Detailed Agenda for Issue Specific Hearing 2 – Environmental Matters including: Ecology and Biodiversity, Historic Environmental, Landscape and Visual Impact

Drawing Title
FIGURE 8-1: STATUTORY DESIGNATED SITES WITHIN 10KM (INTERNATIONAL) AND 2KM (NATIONAL) OF THE ORDER LIMITS

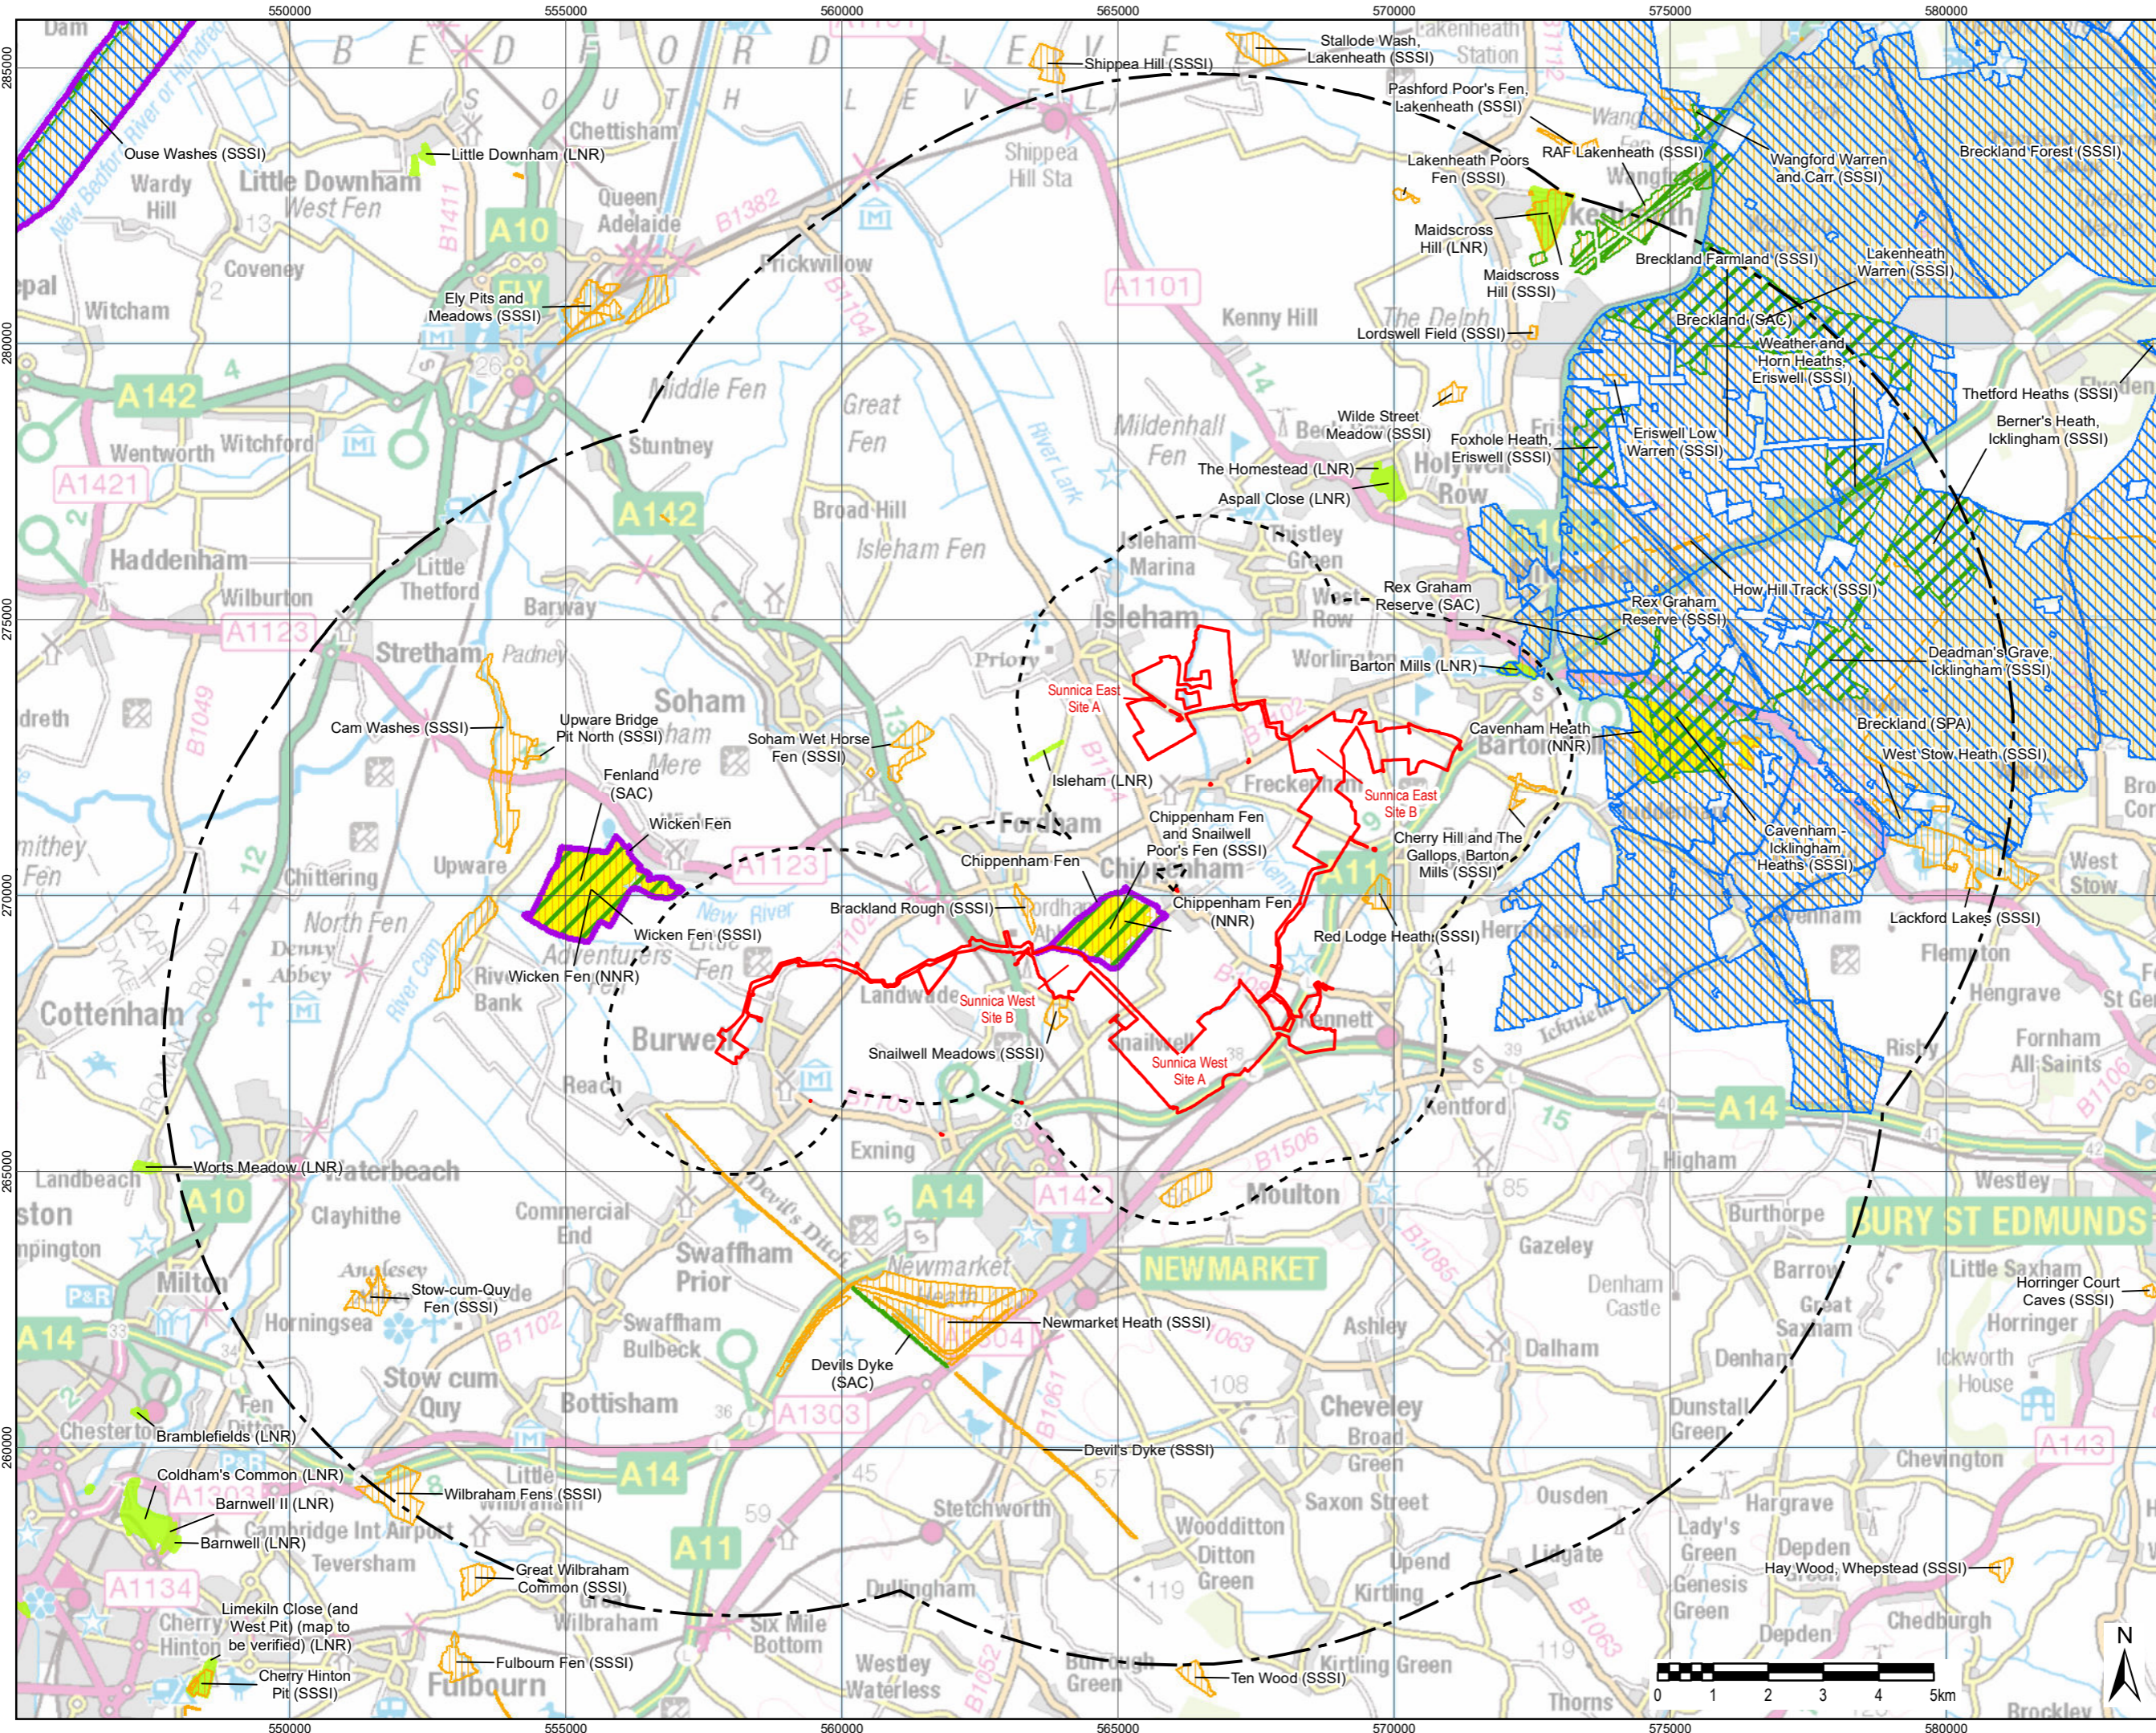
d) Impacts on Chippenham fen & Snailwell Poor's fen and potential mitigation	Natural England was satisfied that impacts to Chippenham Fen were adequately addressed in previous documents. It is noted that in the document 8.52 update by the Applicant on Heritage

Matters and Substation Connection [REP3A-037], that it is now proposed to remove field W01 from the development. This increases the distance between Chippenham Fen and the nearest development site. Natural England does not consider this to have a detrimental impact on Chippenham Fen. We also understand that this means there will be no wetland creation in ECO4, adjacent to Chippenham Fen.

e) Impacts on other designated sites and adequacy of proposed mitigation	Natural England's previous advice has been that we do not consider there to be impacts on other European or nationally designated sites (SSSIs) and this remains the case.
